The Sizewell C Project

**Natural England's Comments on Draft Sabellaria Reef Management and
Monitoring Plan**

Planning Inspectorate Reference: EN010012

24th September 2021

Figure 3.1: Locations of Unit 1 cooling water intake head position options (two to be installed) at the offshore Coralline Crag.

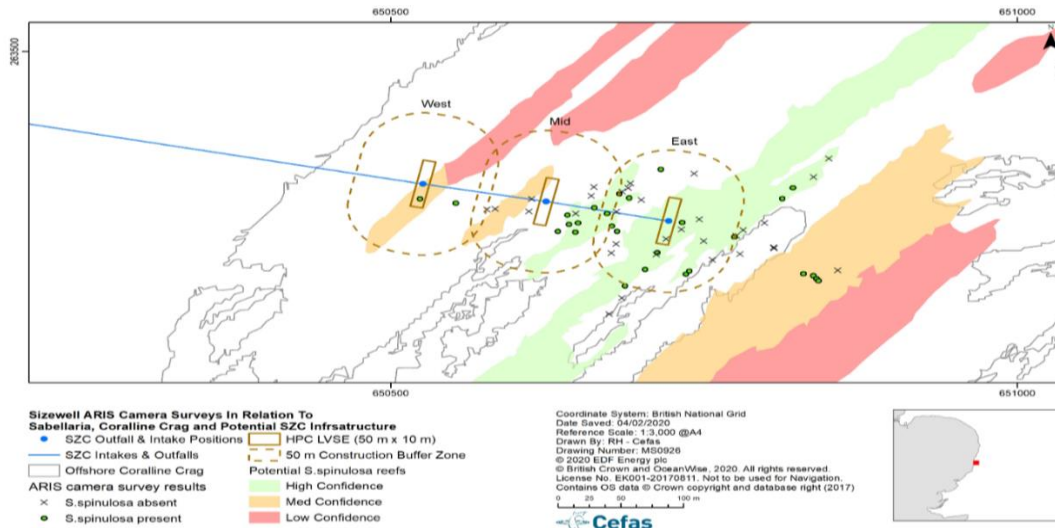
3. Section 3.2 on minimising impacts is welcomed. However, we advise that monitoring may need to be greater than the 50 m construction zone given anchor spread and drag. Therefore, our position is that the use of anchors over jack up barges may not necessarily minimise the impacts.

6. Section 4 - In the introduction, it would be beneficial to highlight that a pre-construction survey will be undertaken no longer than 18 months prior to commencement to inform mitigation measures.
7. Section 4.1 - Natural England reiterate point 3 above, that the construction zone may need to be greater than 50 m if anchors are to be used.
8. Section 4.3 - The monitoring schedule is welcomed by Natural England.
9. Table 5 - Please be advised that we would expect Year 0 (baseline) monitoring to be immediately after the works/disturbance have completed rather than before.
10. Section 5 – Natural England reiterate point 5. above i.e. will this be a named plan on the DCO/DML?
